# A. A. Takla Engineering, PLLC

**Project:** 57 Inlet View  
**Location:** Sanford, NC  
**Company:** Freys Building and Remodeling  
**Care Of:** Jeff Greer  
**Subject:** Renovation - Structural Modifications  
**Job Number:** 0290-23

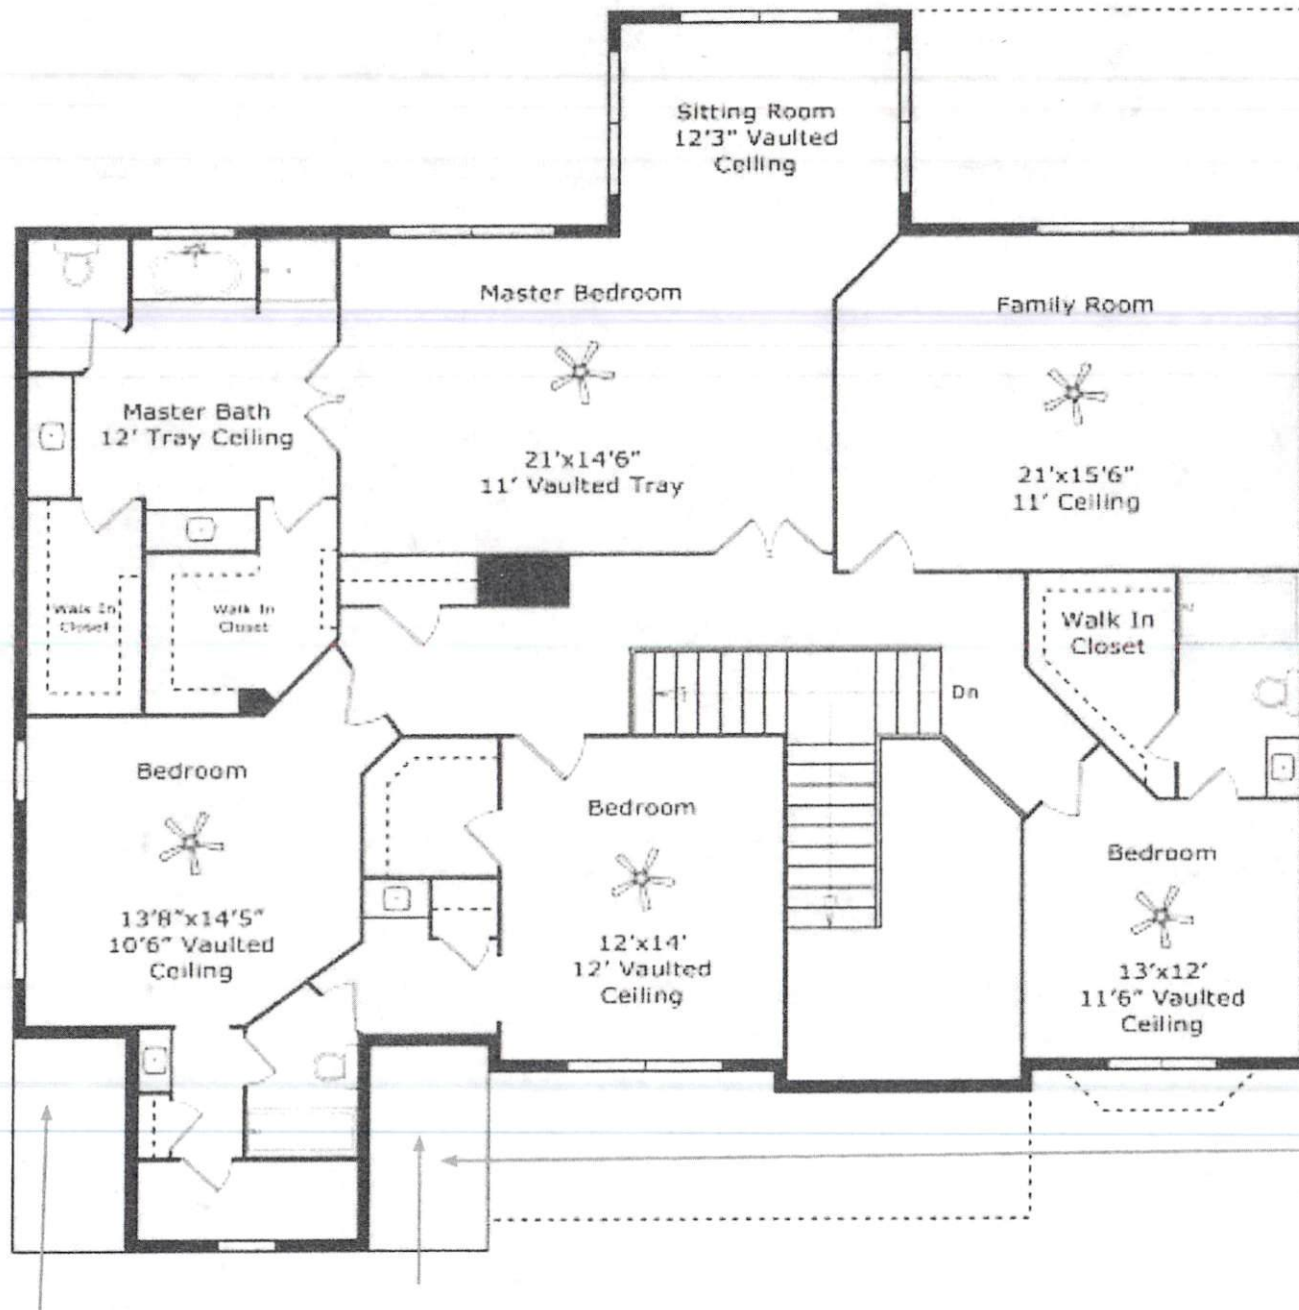
1) Several windows, interior doors and the master bathroom shower niches will be installed and/or relocated. Based on review, put simply, a (2)2x10 header supported by (2)2x4 jack studs at each will be adequate to accommodate all openings (non of which are over 6' wide). Note, the master bathroom niches should end no closer than 12" from the rear-left corner of the 2nd story in neither the left exterior wall or the rear exterior wall. Ensure exterior openings feature king studs per code (at least 2 at each end for openings of 6' wide). Lastly, no reinforcements within the 1st story will be required to accommodate the change in loading configuration given their generally light loading.

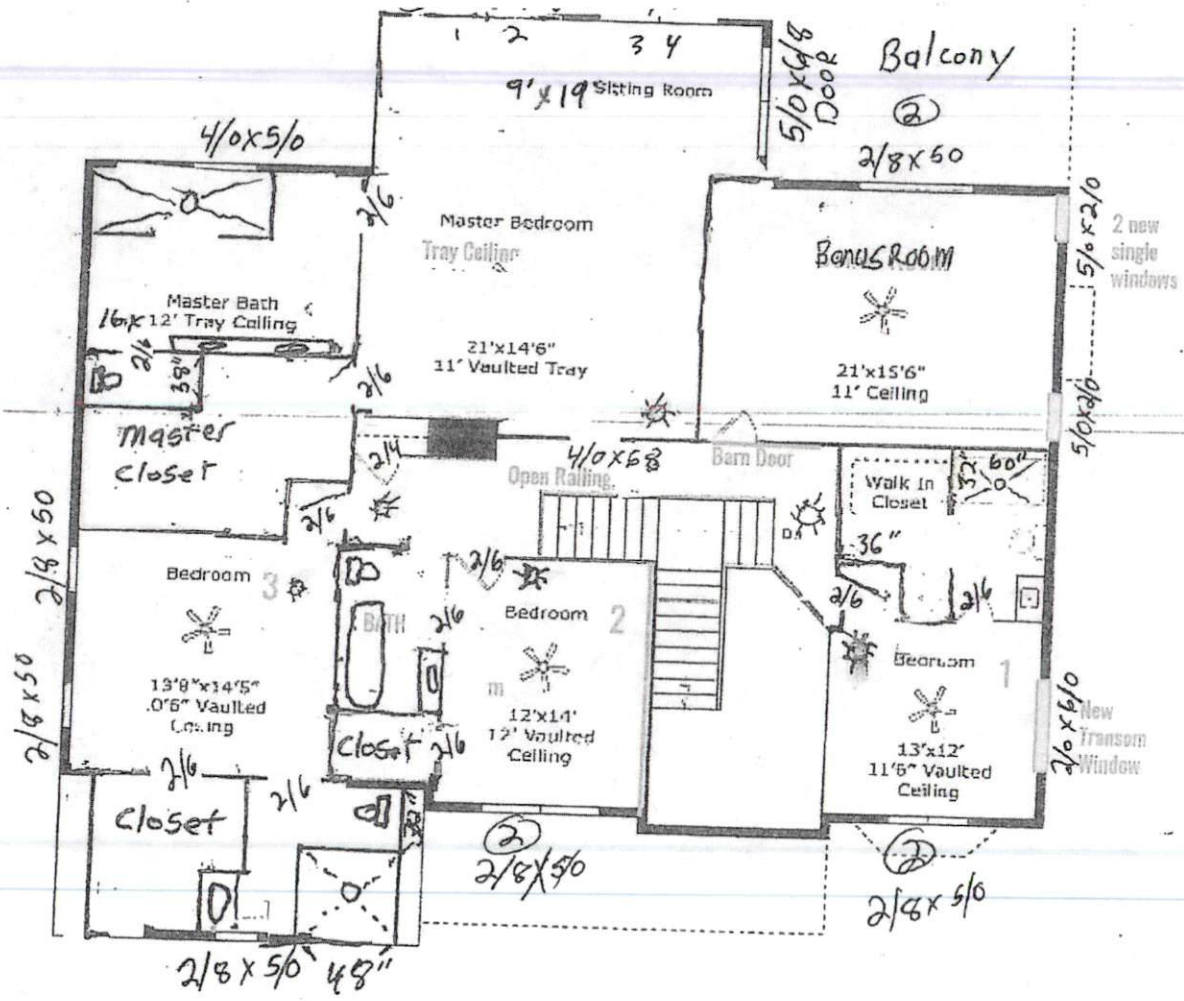
A) To move the right master bathroom wall ~ 3' to the right, we recommend installing either a (2)14" LVL or (3) 11 7/8" LVL at the location of the existing wall. The header may be flushed or dropped as desired and will span ~ 14.5'; Header shall be supported by (3)2x4 jack studs at each end. If 3 ply option is selected and flushed, secure with (5) 10d nails spaced at 12" on center driven from both faces. In the first story hallway, below the forward stud column, install at least (5) 2x4 studs within the hallway wall; providing solid blocking to the first story wall wall. No first story reinforcements are required to accommodate the rear end point load.
